About the application

Application number: 2021/93006	
What is the application for?:	Conversion of existing barn to form 8 dwellings, erection of 10 dwellings, demol
Address of the site or building:	Yew Tree Farm, The Village, Farnley Tyas, Huddersfield, HD4 6UQ
Postcode:

Viewport 3 - Inbound 11.85m Refuse Vehicle - 1:500

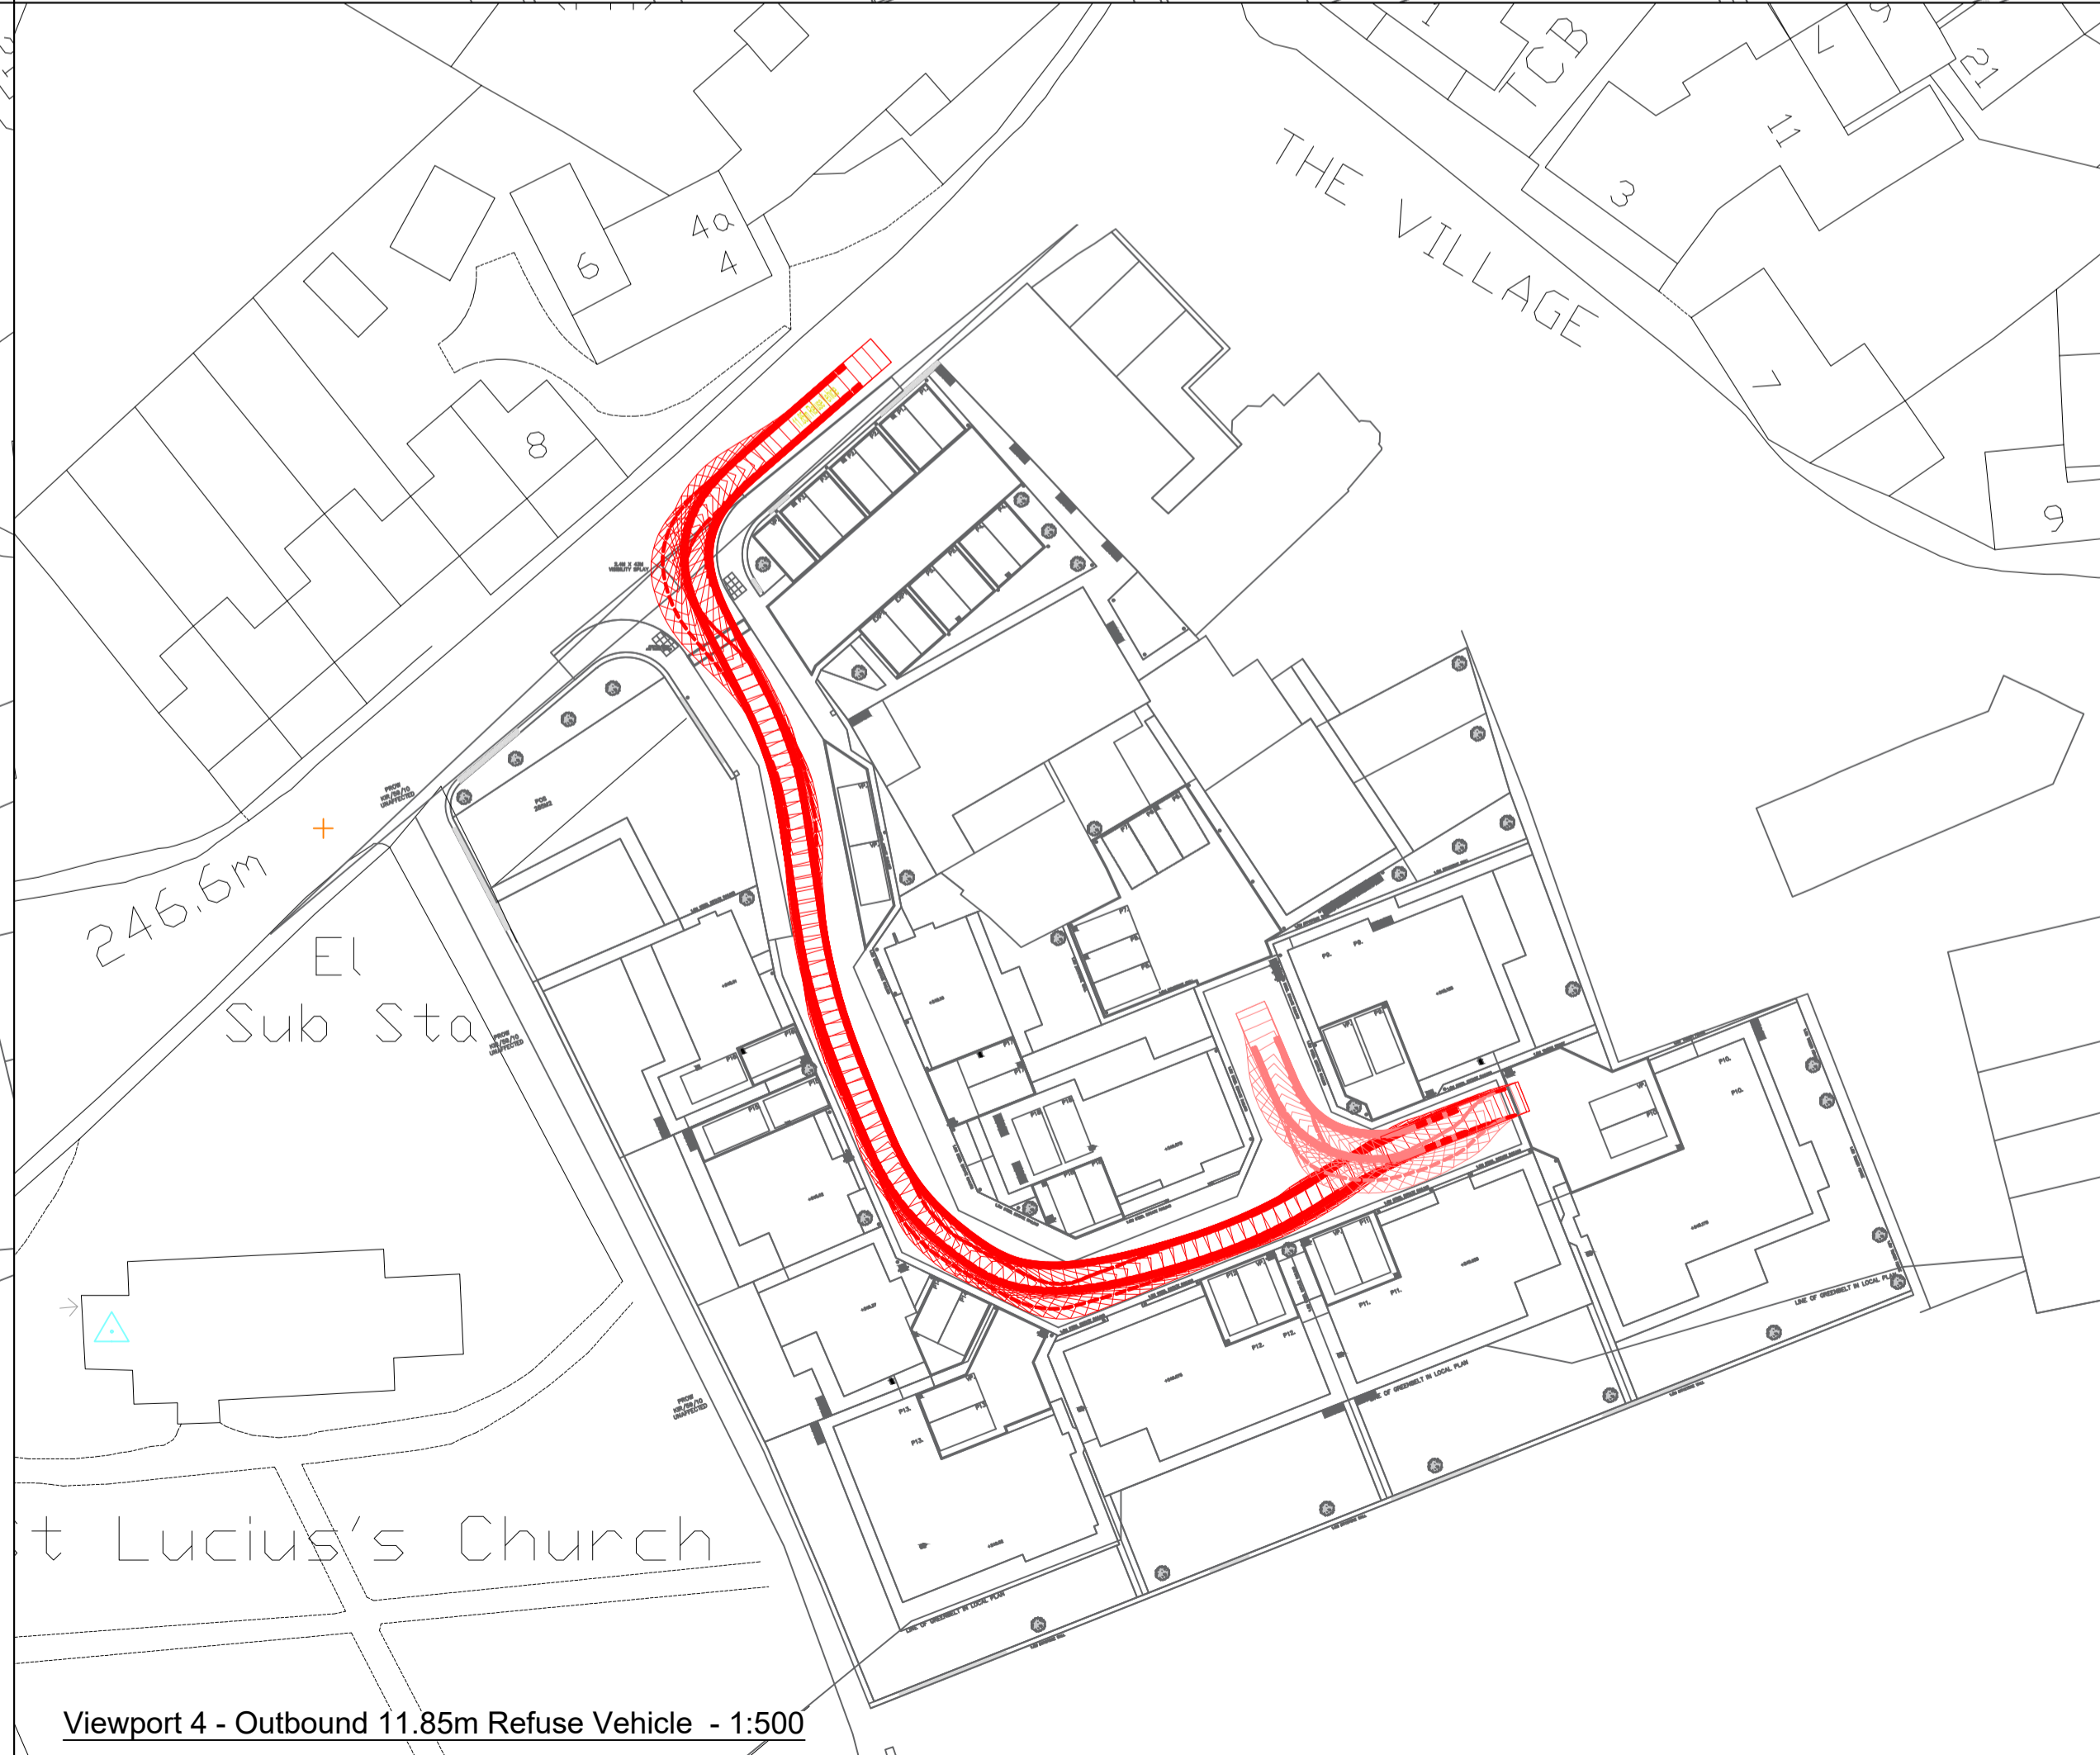
The development access proposed will mean that traffic exits onto a road with reduced visibility in either Is this not in contravention of existing highway junction visibility splay requirements? In addition cars are usually parked outside the houses immediately opposite the entrance to the development. This effectively represents an additional hazard for cars exiting the proposed development onto the main road. If the development is to proceed with the exit point proposed could traffic calming measures on the main road not be introduced to reduce the speed of passing vehicles and the potential for collision
